From: Lisa Coney on behalf of Daun Johnson
Sent: 27 February 2013 13:41
To: Julie Grieves
Subject: FW: AL/8/13/ Amended Planning Drawings

EXISTING ELEVATIONS

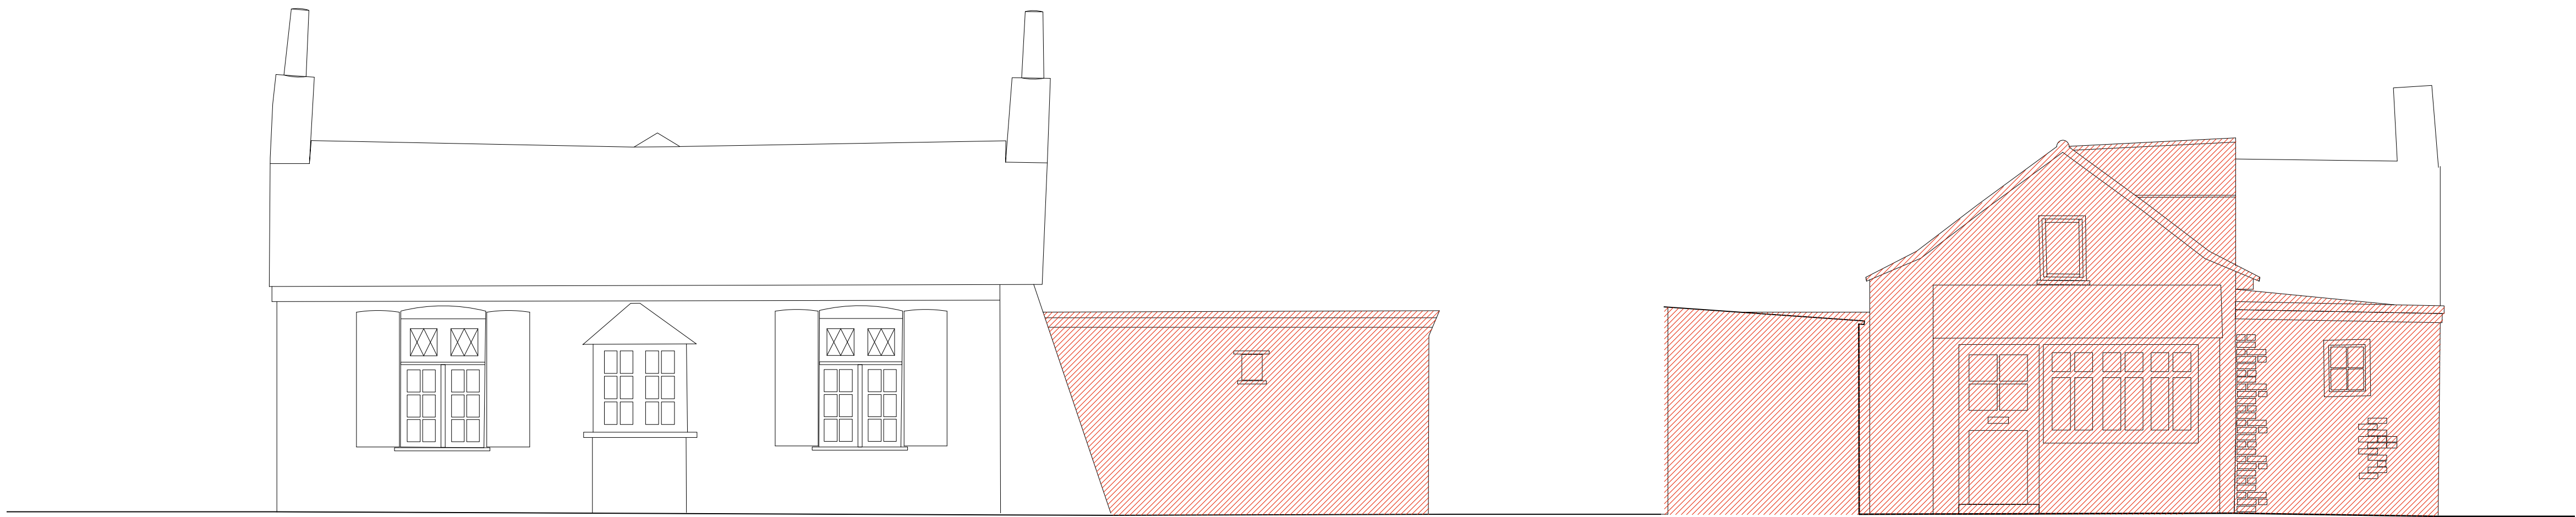
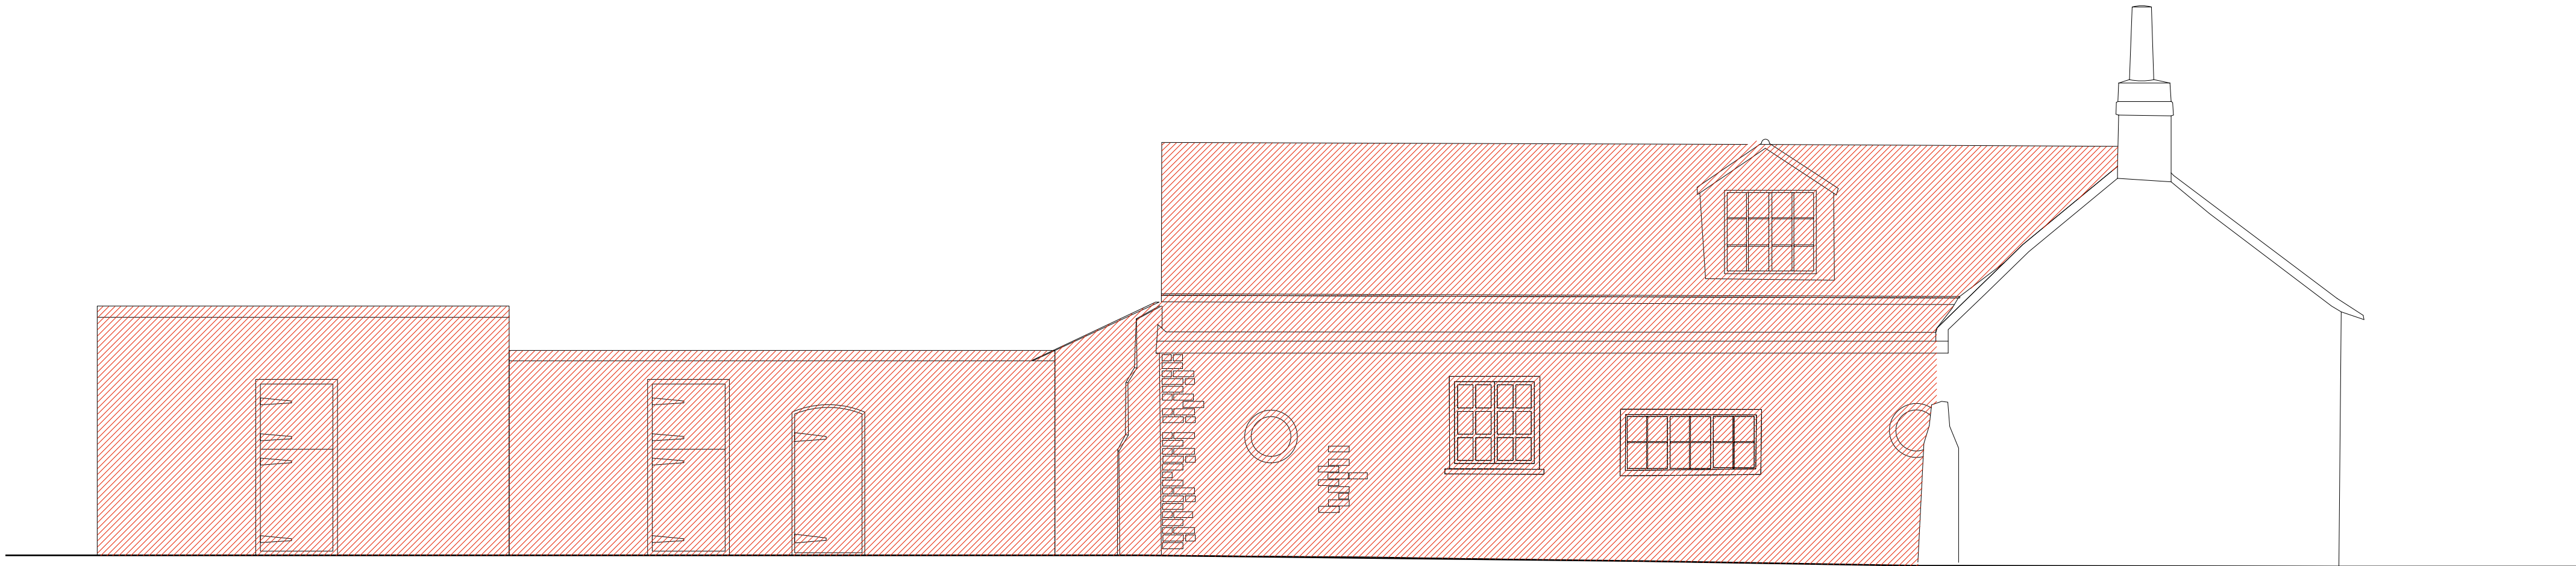
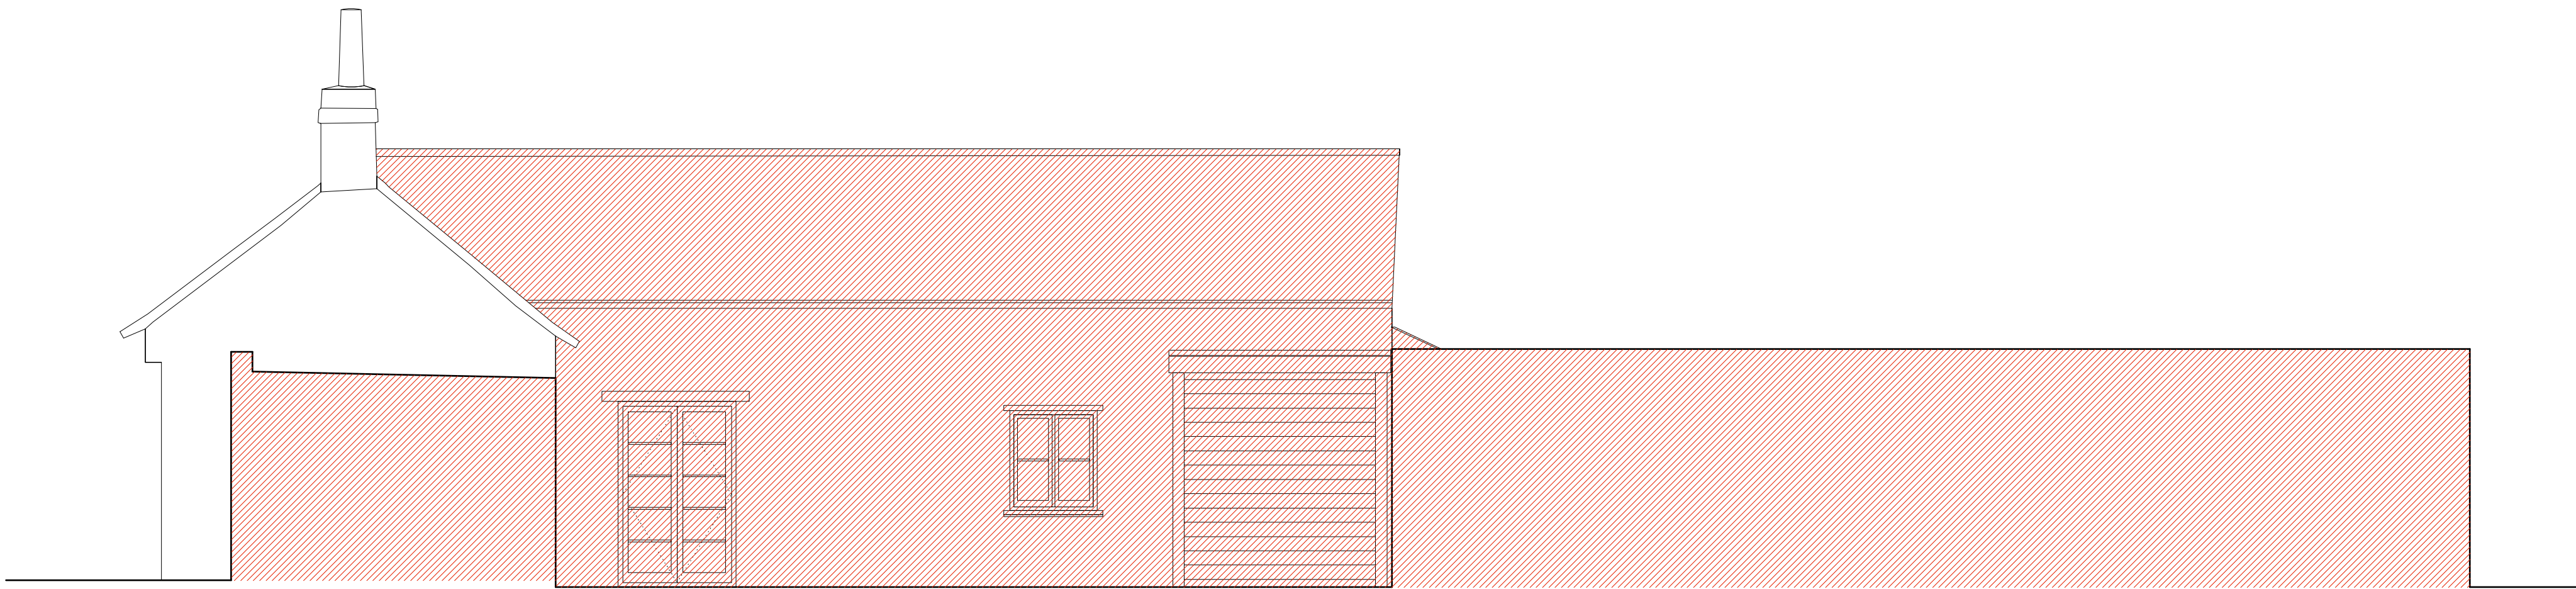
On the exiting front ground floor plan there is a window for Bedroom 1 that is not shown on the existing front elevation.

Also, please confirm that on the existing side elevation (04) that ship lap cladding is being used and not a garage door.

I have now updated the existing drawings to your comments - please find attached.

And yes, as per label on the existing elevations, ship lap cladding is used and it is not a garage door.

EXISTING SECTIONS AND ELEVATIONS

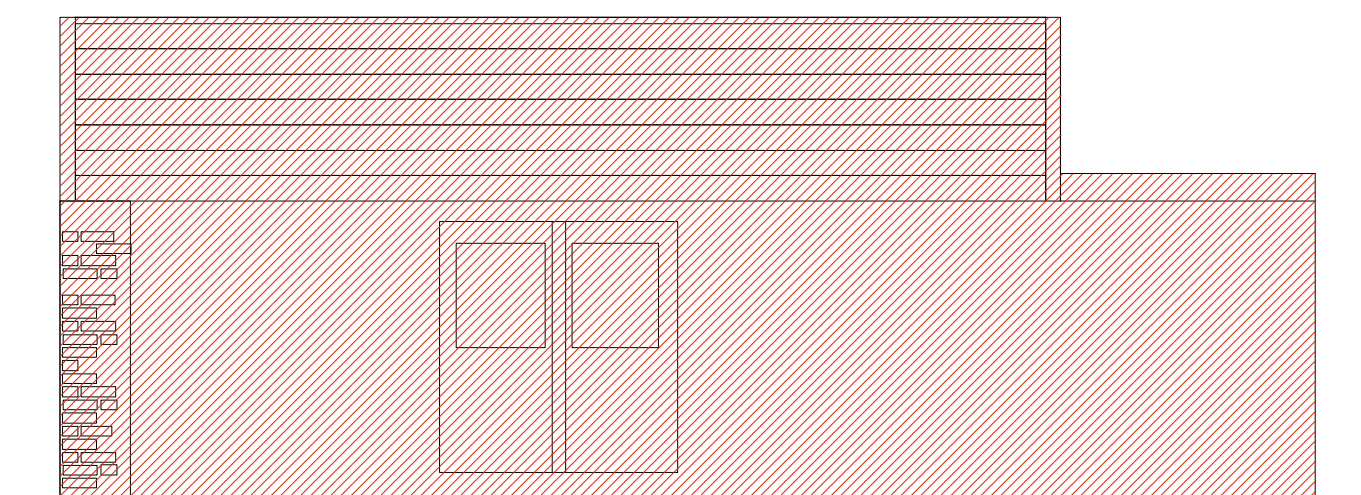
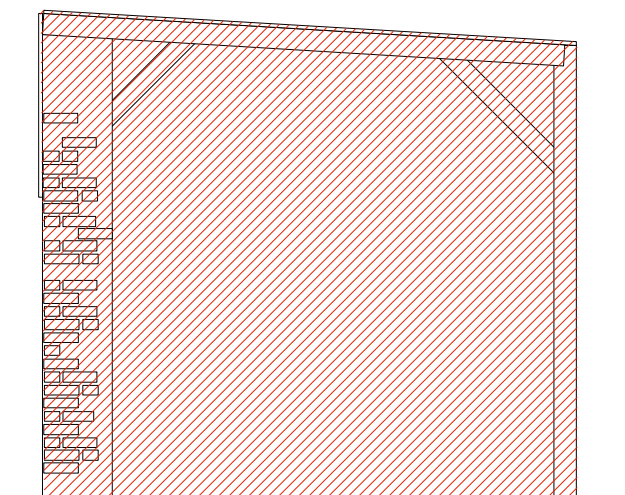
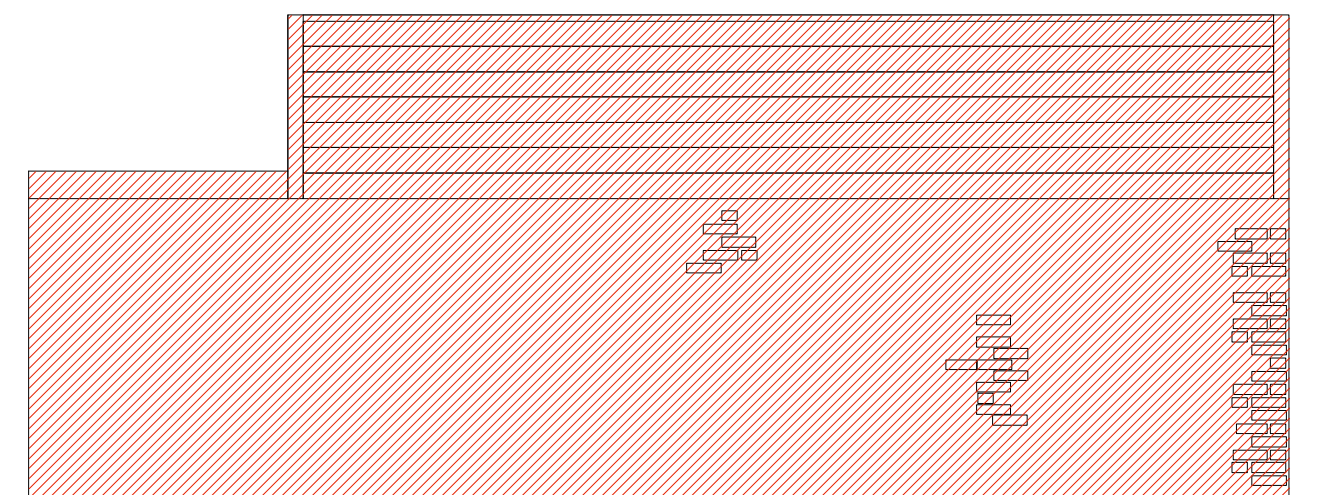
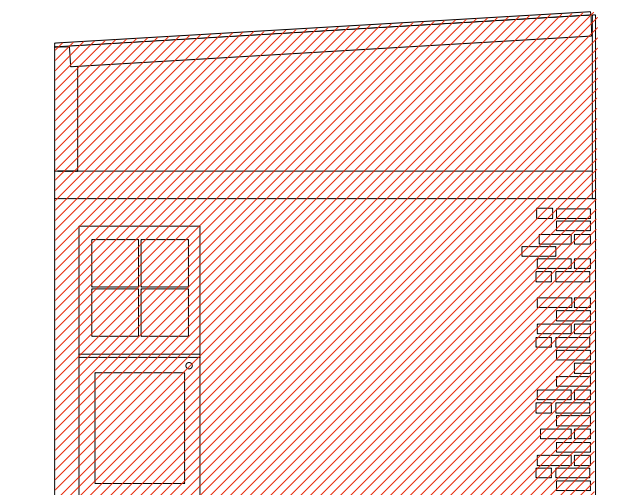
Please show the doors on outbuilding 1 on the side elevation.
